# WALDEN PRESERVE 2

## Filing No. 4

### Grading & Erosion Control Plans

PCD  
719-520-6300

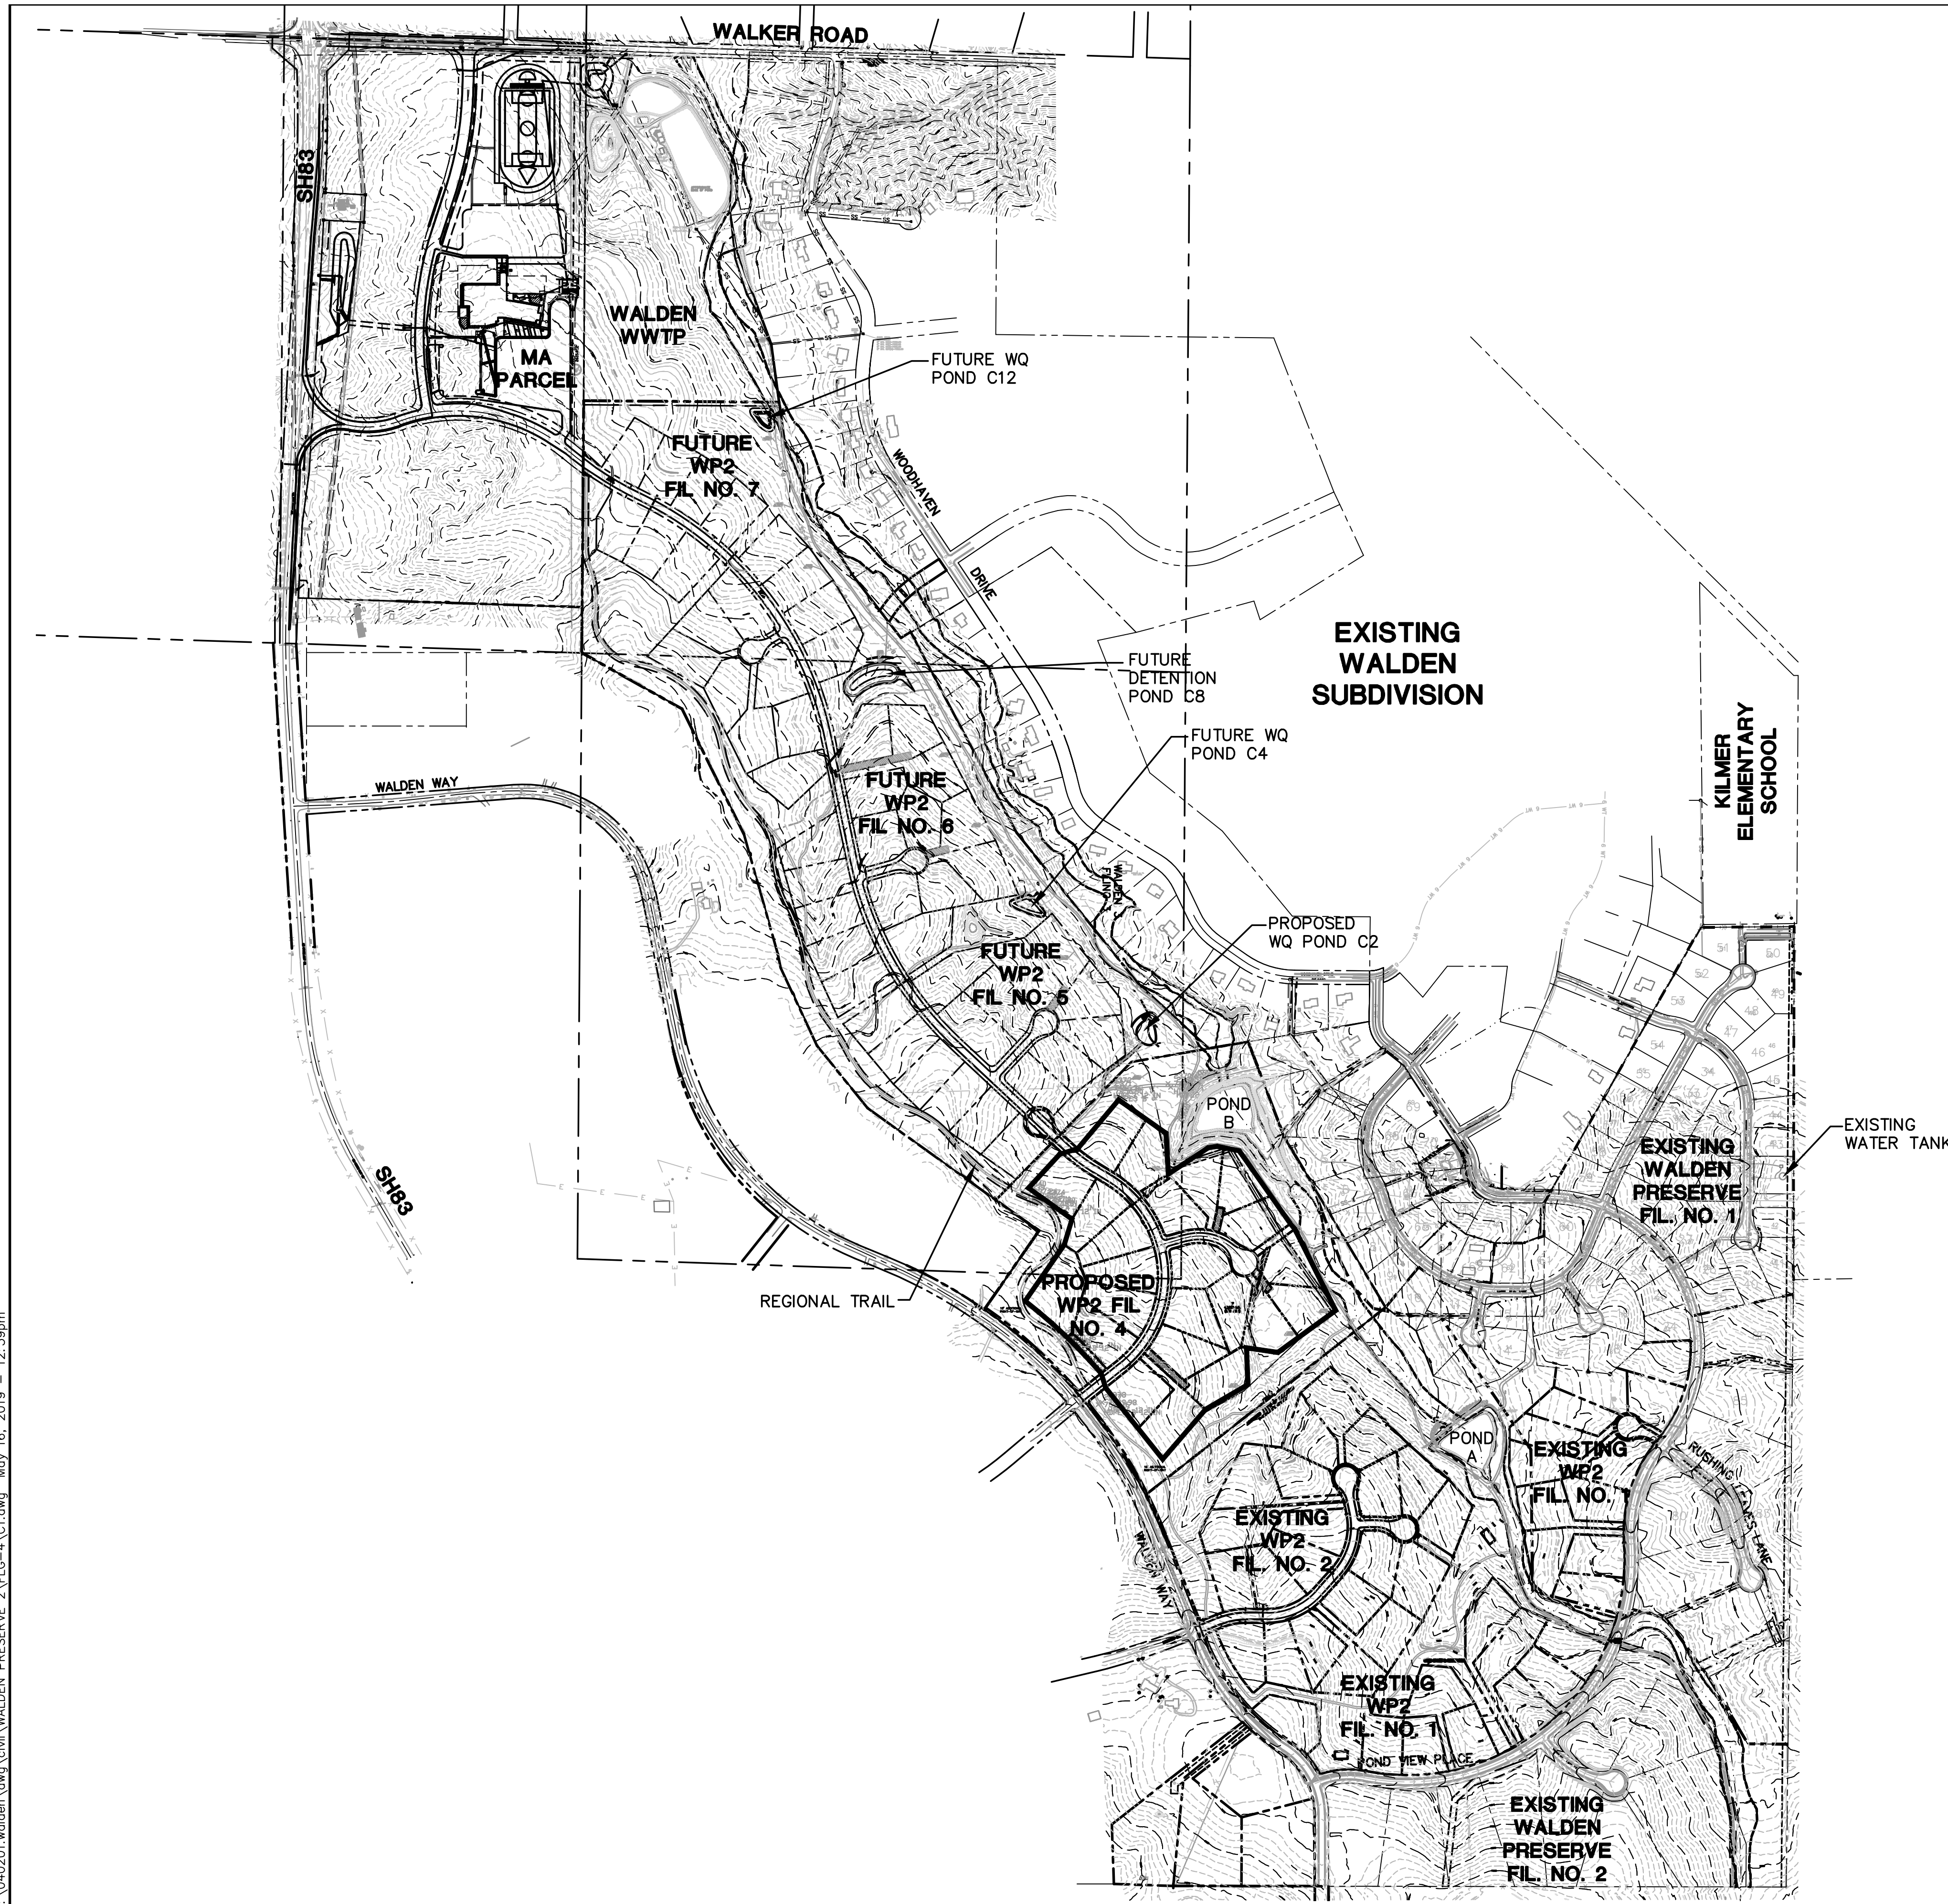
The drainage map called for a 36" culvert across lots 8,9,10

**SITE GRADING & EROSION CONTROL PLAN**

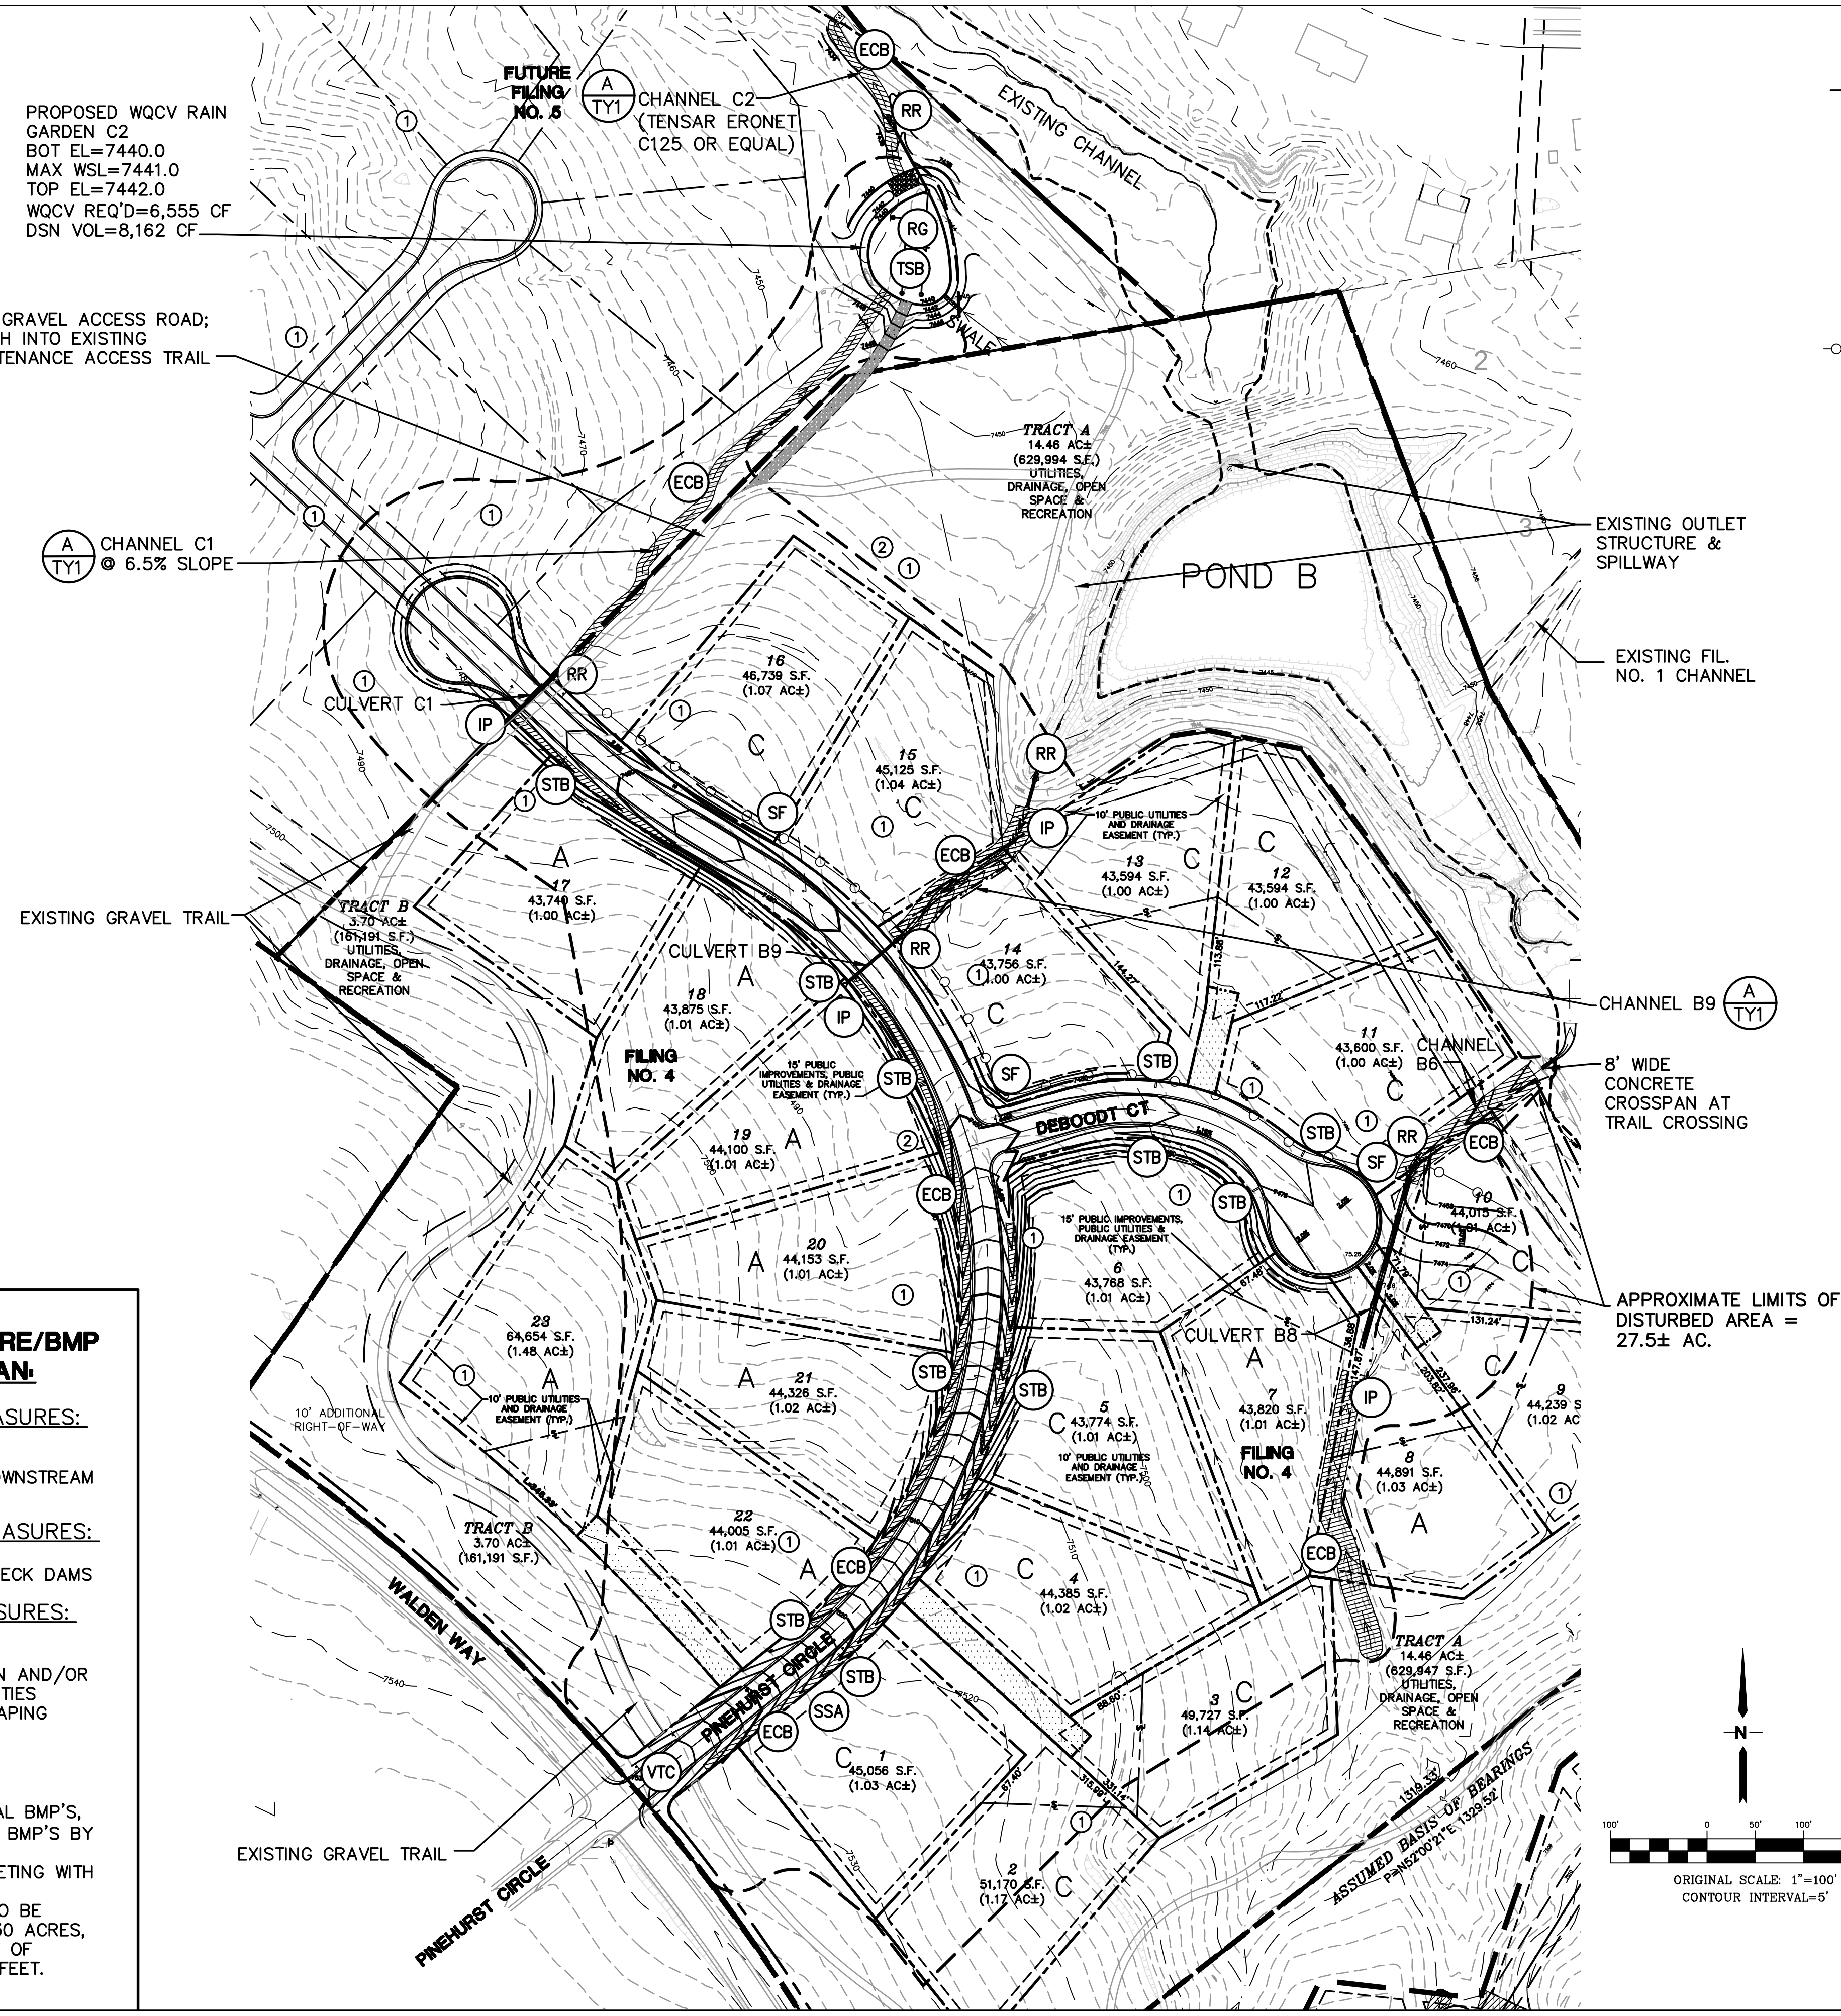
Update the limits of disturbance to encompass Filing 4 improvements only.

Provide a temporary cul-de-sac. Show the grading for the temporary cul-de-sac.

Label the trails as existing or proposed. If the trails are being constructed with filing 4 then the limits of construction/disturbed area should include the trails.

Were these part of the proposed grading with Filing 1? Identify as not a part of Filing 4.

Add the hatch in the legend.
